Rezoning Transportation Analysis

Petition Number: 2023-045

From: Jake Carpenter, PE
Jacob.carpenter@charlottenc.gov
980-221-5675

Date	Description
7-26-23	First Review (IW)
8-24-23	Second Review (NK)

SHEET NUMBER  
**RZ-1**

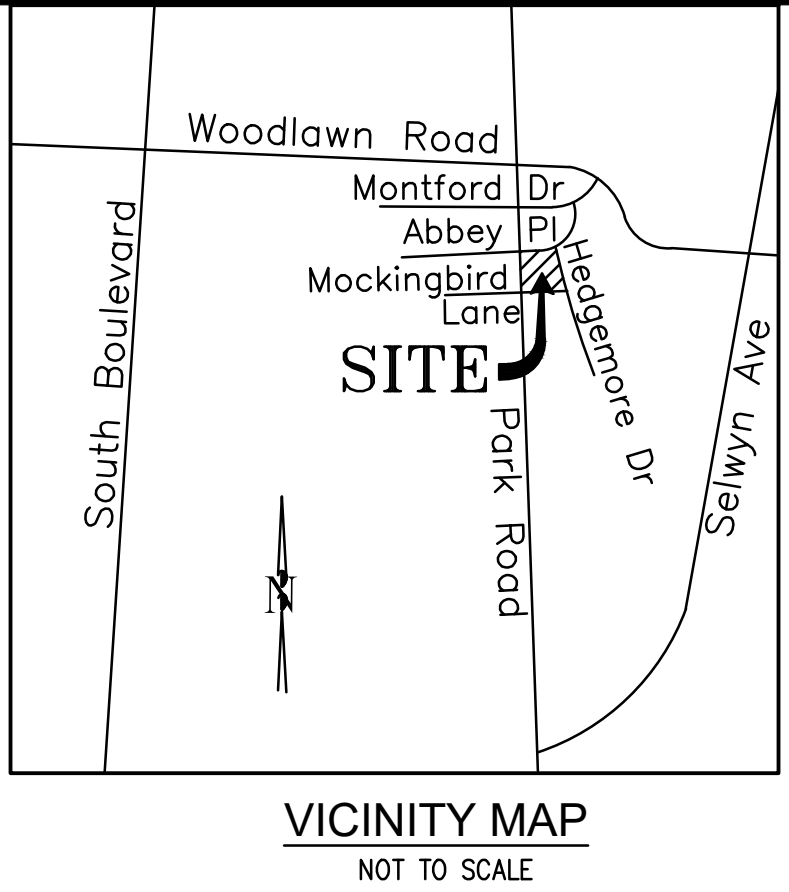
1. Outstanding Comment 7/26/23 Curblines:

- a. The future location of curb and gutters are being shown accurately for all abutting roads as specified in the previously approved rezoning.

Label and dimension the curb and gutter from the centerline for each road on the site plan.

Clarifying Comment 8/24/23: Site plan needs to show dimension of future back of curb from centerline.
